Application for Removal or Variation of a Condition following Grant of Planning Permission or Listed Building Consent

Demolition of existing garage and erection of two storey side extension, single storey garage extension and associated driveway.

2025/62/90493/W

2. Minor amendments to plans and elevations.

DRAWING TITLE:  
Layout Plans

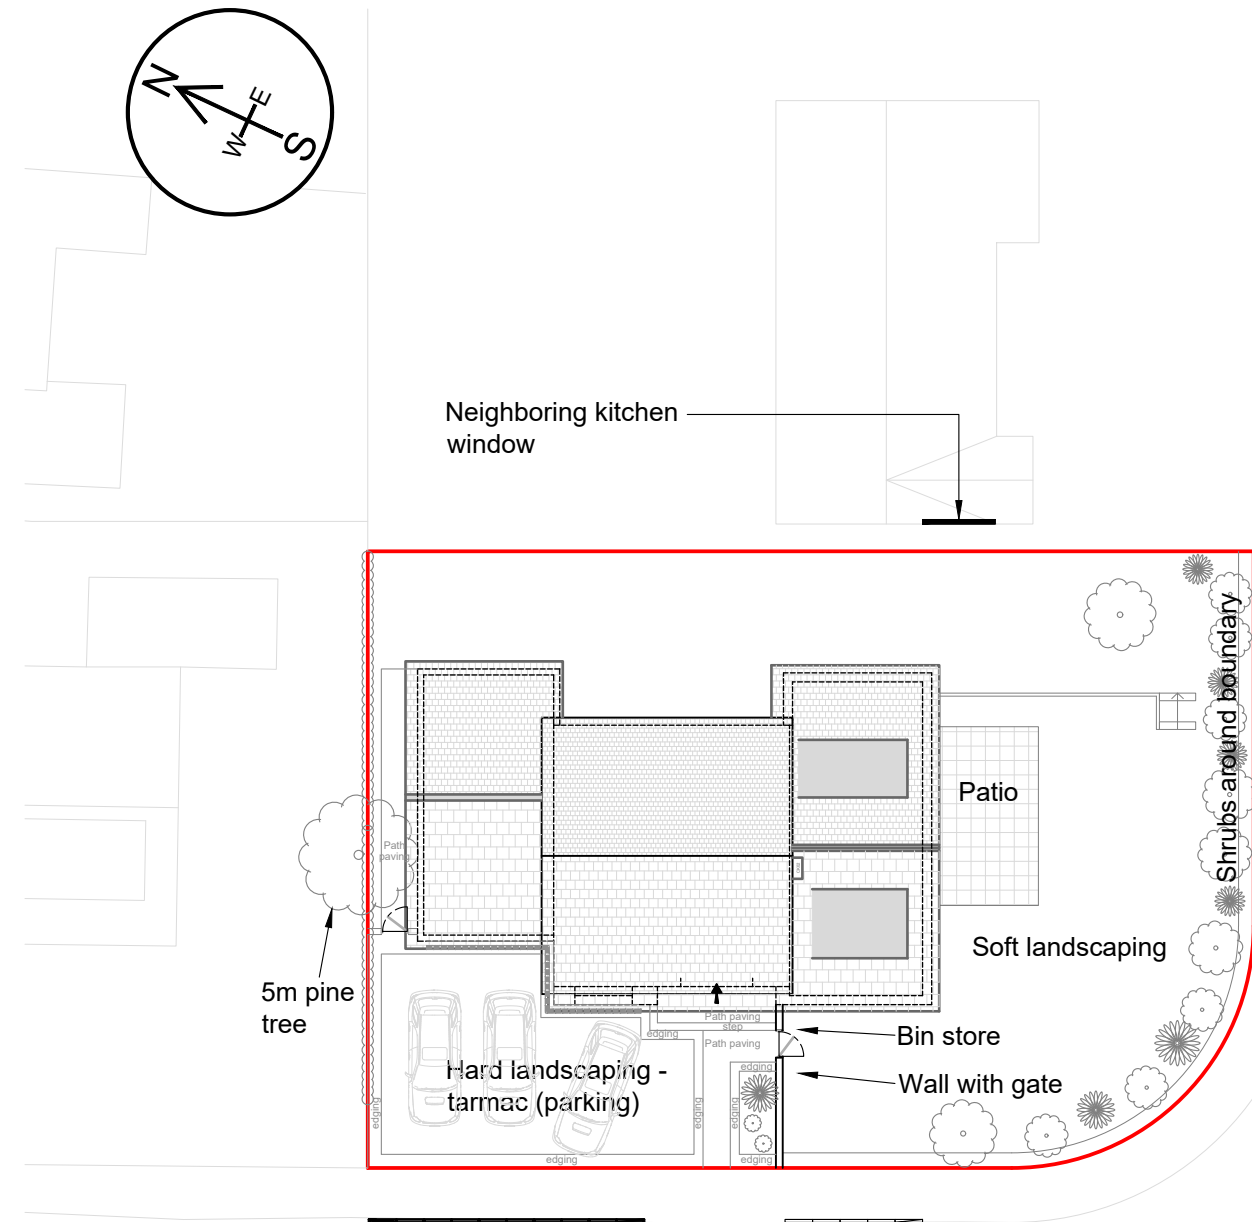
- 2a. Garage door width reduced to 3m to suit building regulations requirements
- 2b. Garage door height reduced to 2.1m to suit building regulations requirements
- 2c. Garage door (person access) relocated to side elevation from rear side to avoid stepped access as ground slopes to a lower level at the rear.
- 2d. Garage window at high level removed as it fouls the roof structure, window lights as part of garage door added.
- 2e. Hall arrangement slightly modified to allow a wider downstairs WC, width of front door sidelights reduced to accommodate new arrangement.
- 2f. Very minor changes to window levels to suit coursing.
- 2g. Folding door from family room to garden width reduced from 3.5m to 3m to suit building regulations requirements.
- 2h. Proposed dropped kerb position moved to align with front of garage to improve proposed garage access.

- 2a. Garage door width reduced to 3m to suit building regulations requirements
- 2b. Garage door height reduced to 2.1m to suit building regulations requirements
- 2c. Garage door (person access) relocated to side elevation from rear side to avoid stepped access as ground slopes to a lower level at the rear.
- 2d. Garage window at high level removed as it fouls the roof structure, window lights as part of garage door added.
- 2e. Hall arrangement slightly modified to allow a wider downstairs WC, width of front door sidelights reduced to accommodate new arrangement.
- 2f. Very minor changes to window levels to suit coursing.
- 2g. Folding door from family room to garden width reduced from 3.5m to 3m to suit building regulations requirements.
- 2h. Proposed dropped kerb position moved to align with front of garage to improve proposed garage access.
